Search application details

Application number: 2024/91465	
What is the application for?:	Prior approval for enlargement of dwellinghouse by erection of additional storie
Address of the site or building:	1, Viewlands, Fixby, Huddersfield, HD2 2HY
Postcode:	HD2 2HY

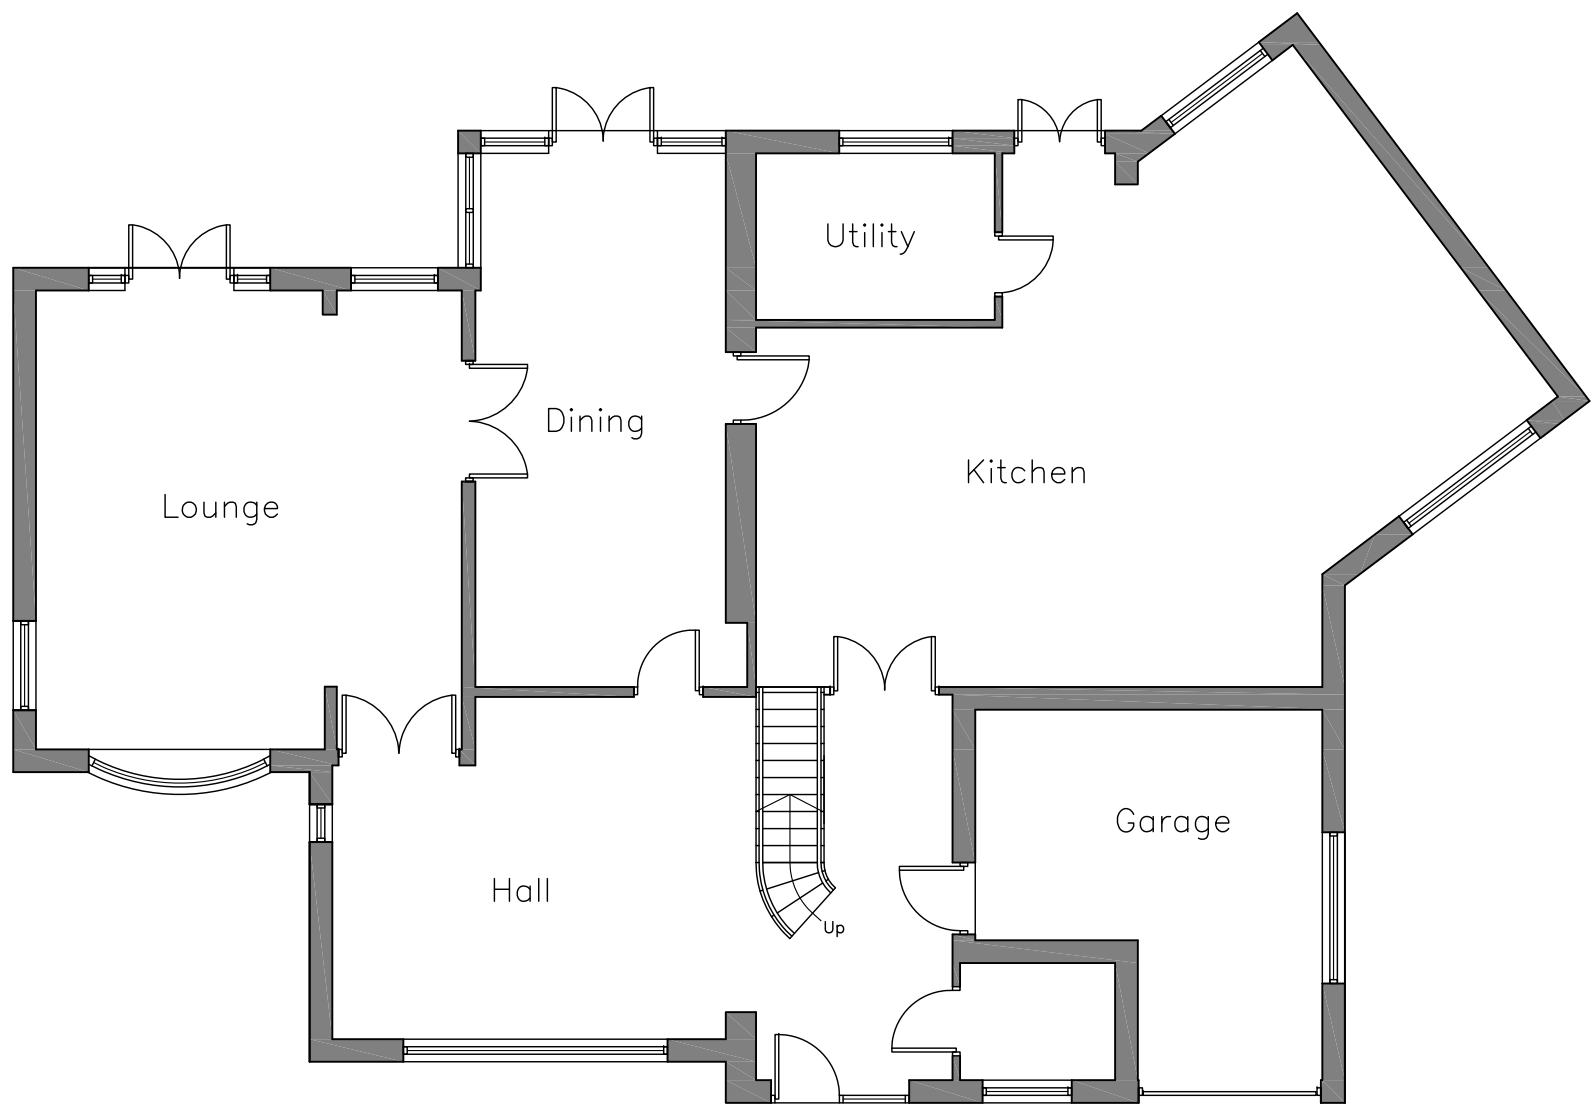
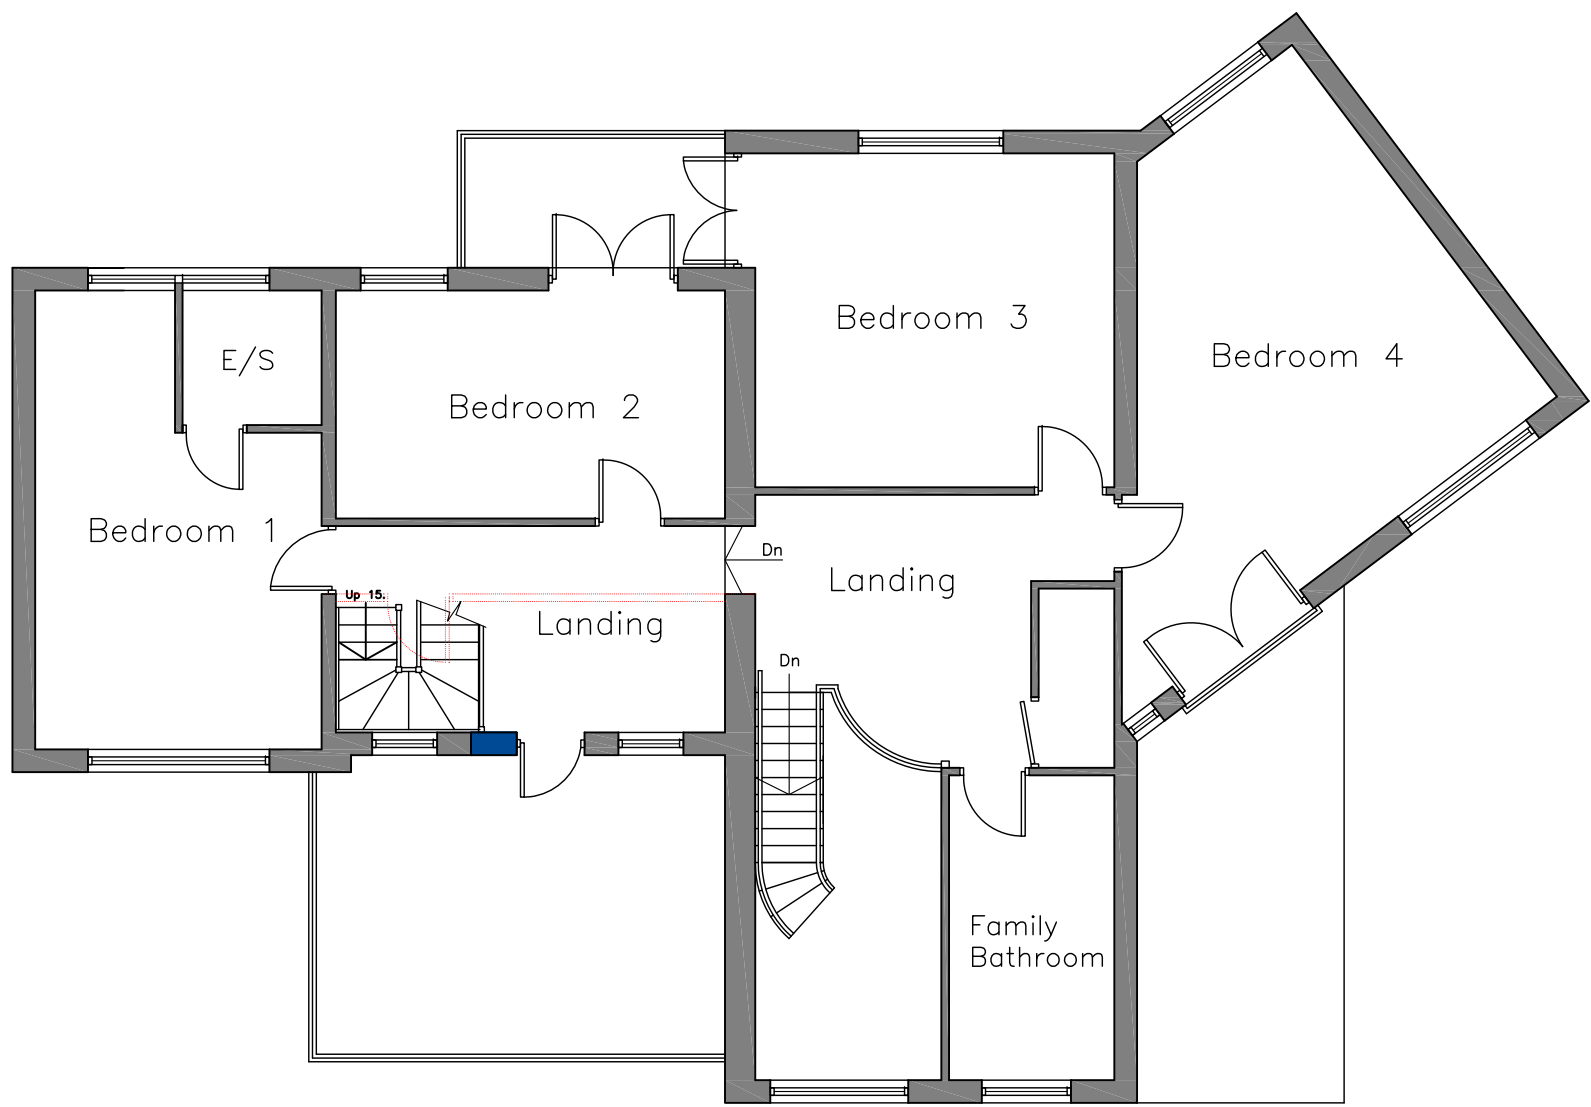
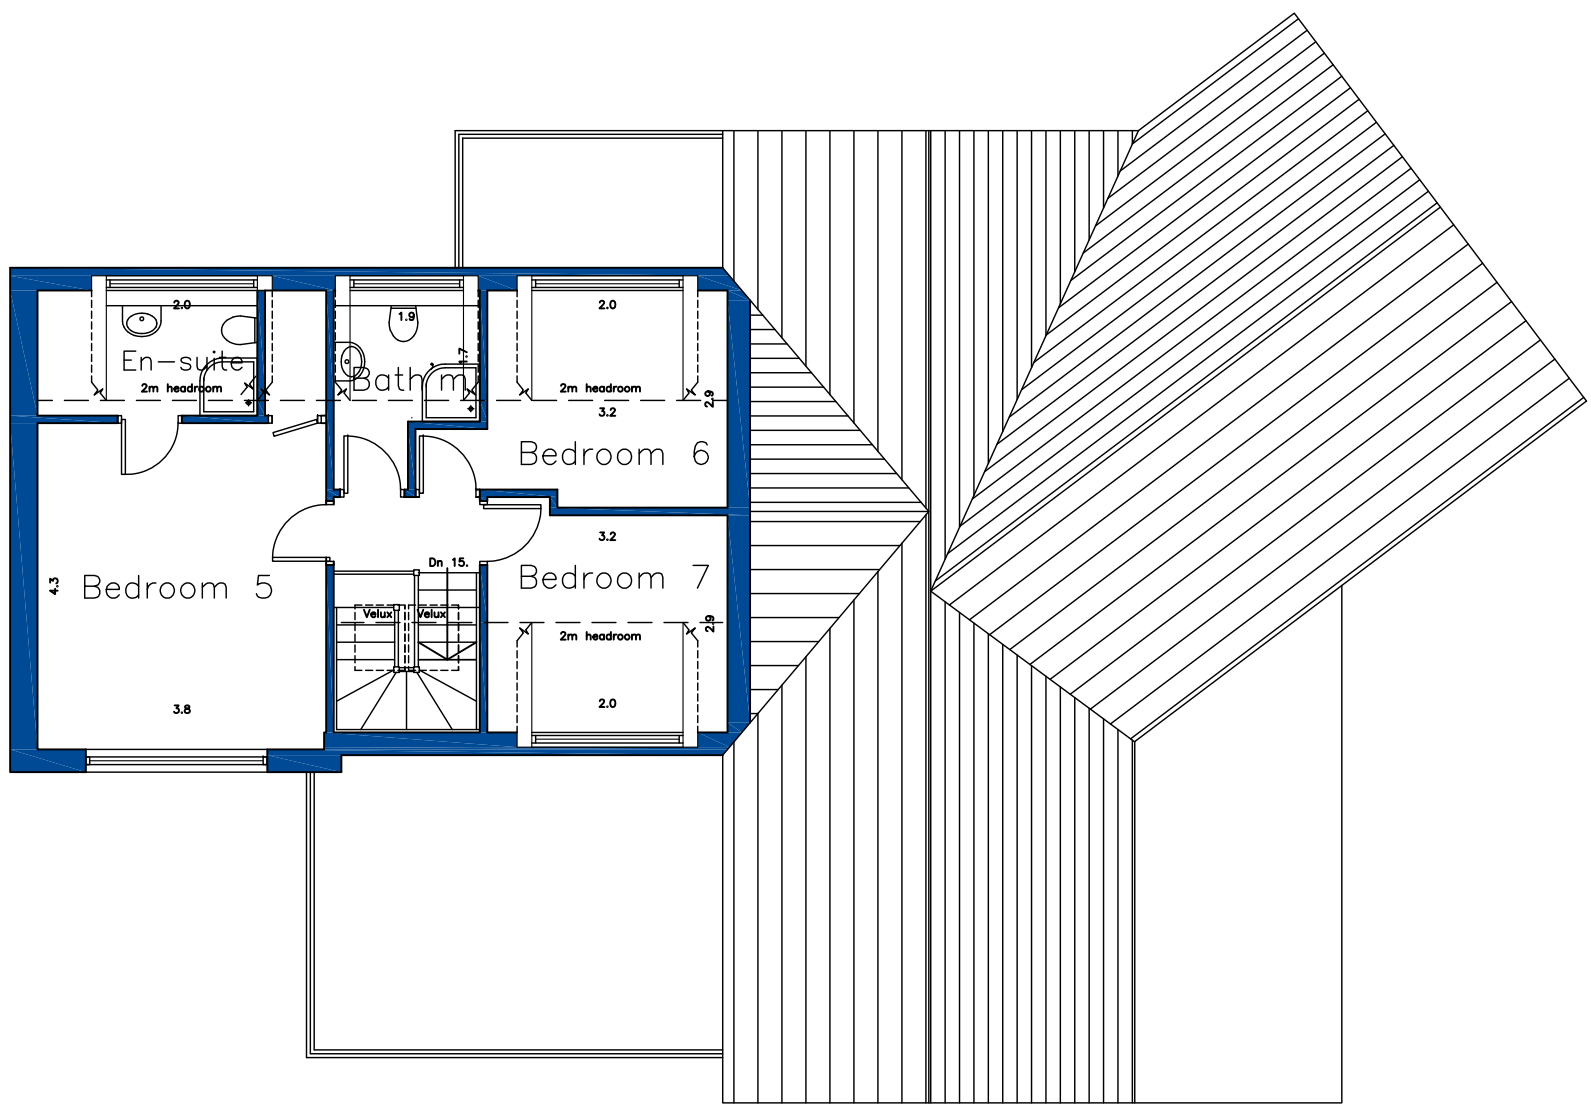
Type of comment: An objection	
Do you wish your comments to be published on the website anonymously?	Yes
<p>1.Planning letter dated 09.06.2021 refers to additional STOREY. Planning letter dated 24.05.2024 refers to additional STORIES.</p> <p>2.Existing and proposed plans show a garage at the site - there isn't one.Parking can already be up to a dozen vehicles.</p> <p>3.Can't find another 3+ story high residential property for miles around - this proposal will have a negative impact on all adjoining properties.Not in keeping with design and architectural features.</p> <p>4.Several applications nearby have been refused permission for only a second storey extension.</p> <p>5.This will have a very negative impact on property values.</p> <p>6.A semi commercial use is not what this property was designed for.</p>
